Consultation Response from: KC Environmental Health (Pollution & Noise Control)		
2020/91611 - 92, New North Road, Edgerton, Huddersfield, HD1 5QP		
Change of use from mixed commercial/residential use to fully commercial (B1 office), demolition of the rear toilet block and associated works (Within a Conservation Area)		
Date Responded: 25th June 2020	Responding Officer: Rebecca Muff	Responding Ref: WK/202014820
This application is for a change of use from mixed commercial/residential to fully commercial. The property lies within a conservation area of mixed use premises, but it is predominately a residential area. Therefore, there are concerns relating to noise generated from the business and the impact this will have on the amenity of the neighbouring residents and we would recommend the following conditions. Electric Vehicle Charging Points (EVCP) The application proposes 15 car parking spaces. In an application of this nature it is expected that facilities for charging electric vehicles and other ultra-low emission vehicles are provided in accordance with the National Planning Policy Framework and <i>Air Quality & Emissions Technical Planning Guidance</i> from the West Yorkshire

PROJECT TITLE: 92 New North Road Huddersfield	
DRAWING TITLE: Sign and Electric Charging Points	
DRAWN: DRW	
DATE: 07/01/2020	
SCALE: 1:200	
DRAWING NO: 19.064/DRW/007	
Signage/Charging Points	
ALL RIGHTS RESERVED DRAWING NOT TO BE REPRODUCED WITHOUT PERMISSION. DO NOT SCALE

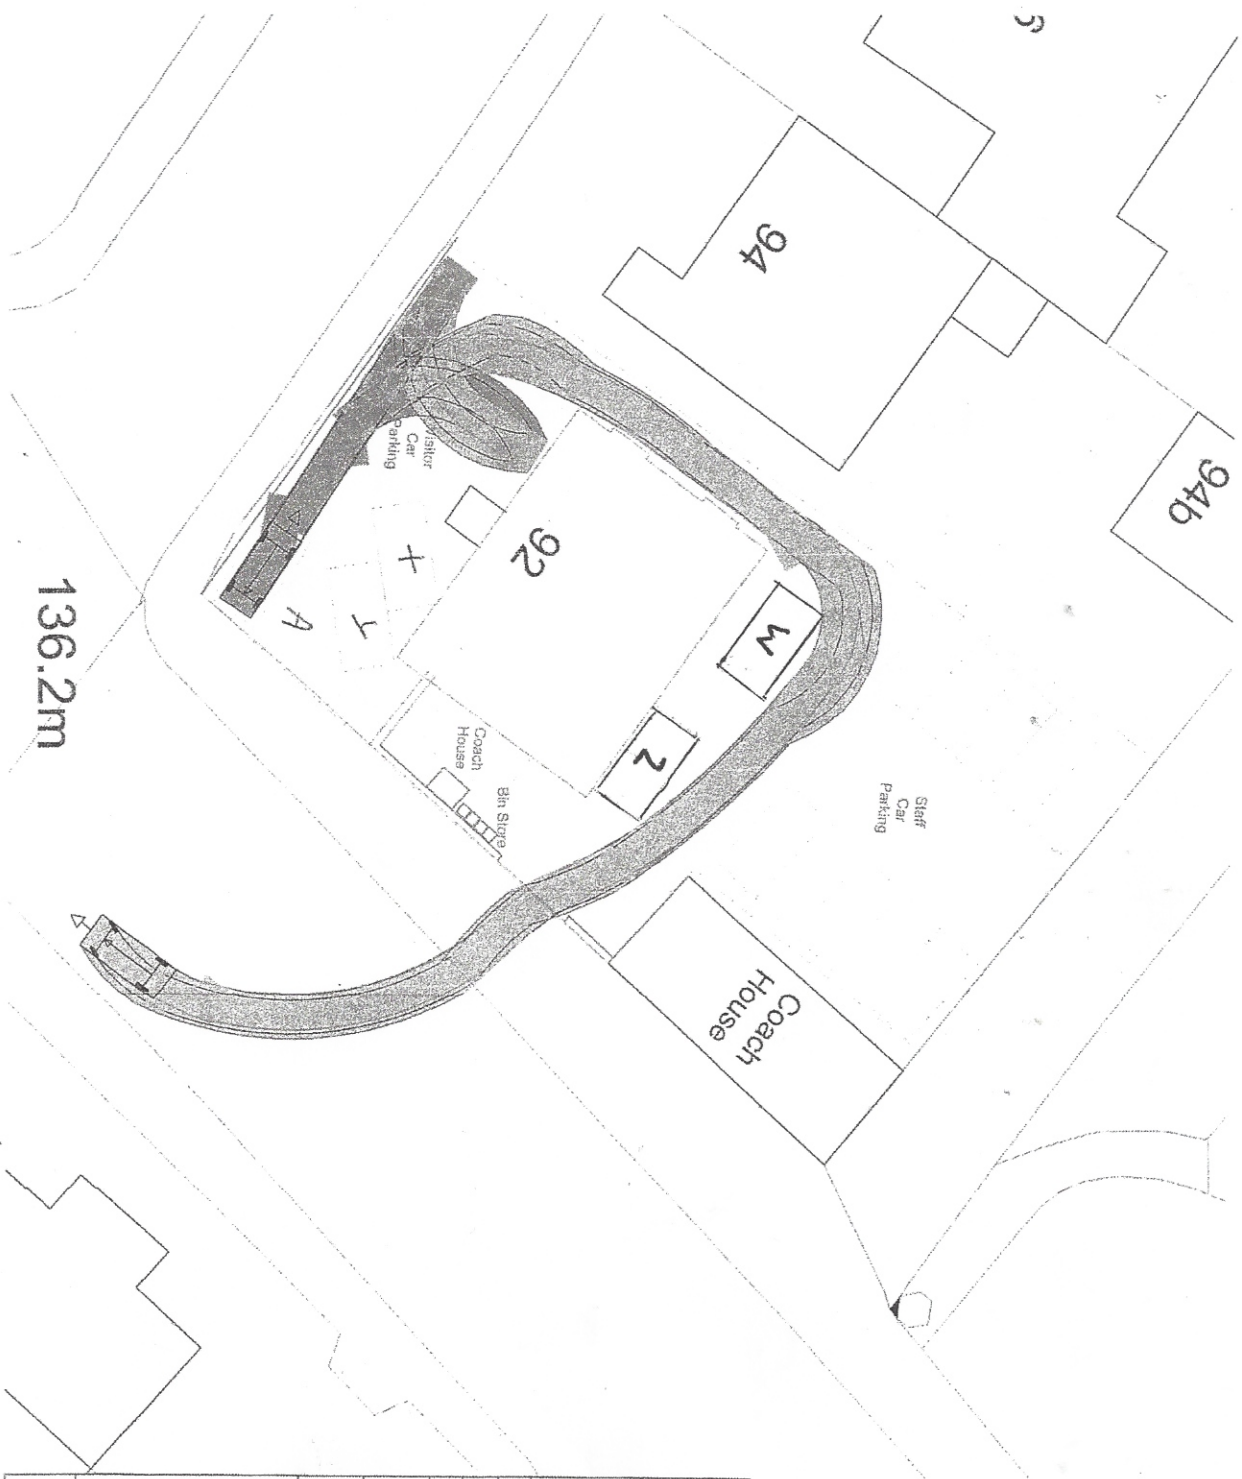
Before the electrical system is installed a scheme detailing the dedicated facilities that will be provided for charging electric vehicles and other ultra-low emission vehicles shall be submitted to and approved in writing by the Local Planning Authority. The scheme shall meet at least the following minimum standard for numbers and power output:

- One Standard Electric Vehicle Charging Point for every 10 unallocated commercial parking spaces

Buildings and parking spaces that are to be provided with charging points shall not be brought into use until the charging points are installed and operational. Charging points installed shall be retained thereafter.

- A Standard electric vehicle charging point is one which is capable of providing a continuous supply of at least 16A (3.5kW). A 32A (7kW) is however more likely to be futureproof

- At non-residential developments, the requirement for one electric vehicle charging point for every 10 parking spaces may initially be reduced to one charging point for every 20 parking spaces with the remainder provided at an agreed trigger point.

- For developments where some or all of the parking is likely to be used for shorter stay parking (30mins to 4 hours) then Fast (7-23kW) or Rapid (43kW+) charging points may be more appropriate. If Fast or Rapid charging points are proposed together with restrictions on the times that vehicles are allowed to be parked at these points then a lower number of charging points may be acceptable.

- The electrical supply of the final installation should allow the charging equipment to operate at full rated capacity.
- The installation must comply with all applicable electrical requirements in force at the time of installation.
